CONFERENCE RECAP

RE: DRAINAGE & GRADING PLAN FOR PEREA'S RESTAURANT  
SUBMITTED OCTOBER 22, 1985 FOR BUILDING PERMIT APPROVAL  
(H-21/D30)

RE: DRAINAGE & GRADING PLAN OF PEREA'S RESTAURANT  
1935 JUAN TABO BLVD., NE (H-21/D30)

DRAINAGE AND GRADING PLAN

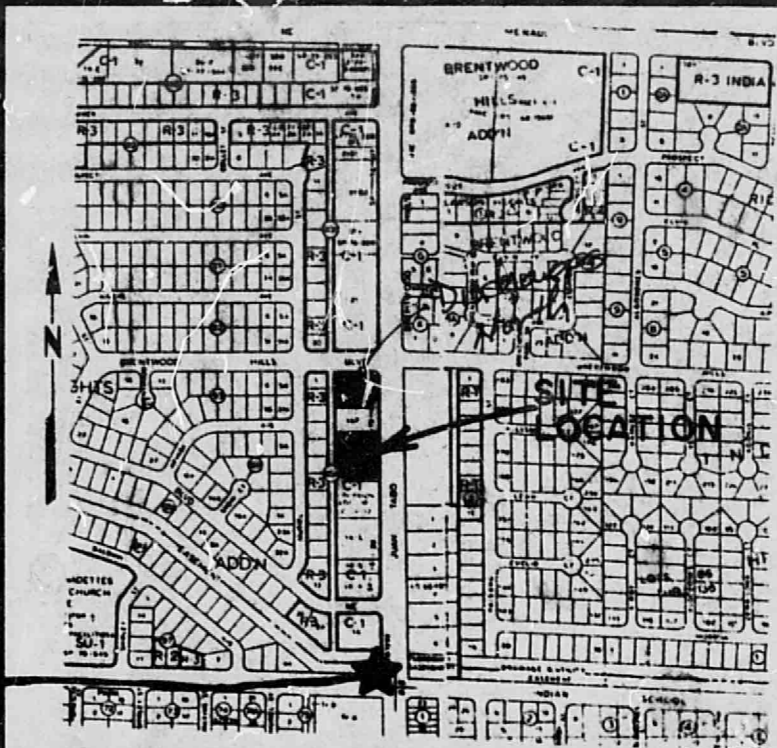
- ① Drainage Plans per DPM
- ② Free discharge to Trench Tube acceptable  
engineer must address - in fill site -  
bottom of water seal - minimum impact - channel down
- ③ Free discharge to alley appropriate but  
must address following:
  - Ⓐ need city approved alley grade
  - Ⓑ impact to adjoining properties in alley
  - Ⓒ erosion impact

1. The alley must be improved to have capacity for total developed flows entering it, before your site can be allowed to discharge into it. If it is not paved, hydraulic calculations must show that it is stable at the 100 year peak runoff rate and has capacity without affecting the adjacent properties. These items were identified in the pre-design conference.
2. If ponding is provided, it must have a drainage outlet with an invert at pond bottom to drain the pond within 24 hours, in addition to the outlet weir.

It has been brought to my attention by our Drainage Inspector and Street Maintenance Engineer that discharge from Perea's Restaurant can affect off-site private property opposite the public alley. Your Drainage and Grading Plan dated October 18, 1985, was approved by this office on December 27, 1985. This plan showed an existing concrete block wall along the entire west side of the alley. A field inspection revealed that this is not the case. There are two wooden gates along the west side of alley, to access private lots. One of these gates is directly opposite of the rip rap rundown from Perea's Restaurant, with an existing ground elevation at or below that of the east edge of alley. This Grading and Drainage Plan would not have been approved if the actual site conditions had been known, without alley and slope improvements being required to protect adjacent private property along the alley.

Even though the alley was recently graded by the City to contain all runoff along the east side of the alley, this will not be adequate since the unprotected slope between the restaurant's parking lot and alley will erode and fill in any alley grading with sediment. Therefore, the alley will need constant maintenance to protect private lots along the west side of alley.

I feel that the owner has a responsibility to make improvements to the unprotected slope and alley to protect private property opposite of the restaurant property. I also feel that since the Building Permit and Certificate of Occupancy were approved by this office under misrepresentation with your Drainage and Grading Plan, you have some obligation to ensure that this drainage problem is remedied.

Ponding is NOT to be considered for drainage approval; however, minor ponding is provided as a courtesy to the neighbors who use the alley. This pond would reduce the frequency of runoff events into the unpaved alley.

For design purposes, no ponding is assumed. The 100-year uncontrolled runoff will be conveyed to the alley in a rip-rap lined rundown. All of the tracts between the alley and Juan Tabo Blvd. NE have commercial developments and all drain to the alley. The most recent development still has construction debris in the alley. Therefore it would be inappropriate to require this one development to provide ponding of stormwater.

Alley grades for this alley were developed by the City of Albuquerque (copy attached). As shown on the drainage plan the 100-year peak runoff of 10.3 cfs in the alley for developed conditions will be increased approximately 20 percent by this development to 12.4 cfs.

Existing slope =  $(97.74 - 97.11)/200 = 0.003 \%$

For unpaved alley  $n = 0.020$ ,  $d = 6"$ ,  $V = 2.1$  fps

For paved alley  $n = 0.013$ ,  $d = 5"$ ,  $V = 2.7$  fps

These velocities are not conducive to erosion and the alley is bordered by block walls on the west side and a 4- to 6-foot high slope on the east. Also all other tracts on the east side of this alley drain to the alley without ponding. Therefore, the alley will remain stable and adjacent properties will not be adversely affected.

The referenced submittal is approved for Building Permit. The requirement for the small retention pond to have a positive outlet is waived, since it's capacity is negligible (less than 500 cu. ft.) at the proposed weir elevation.
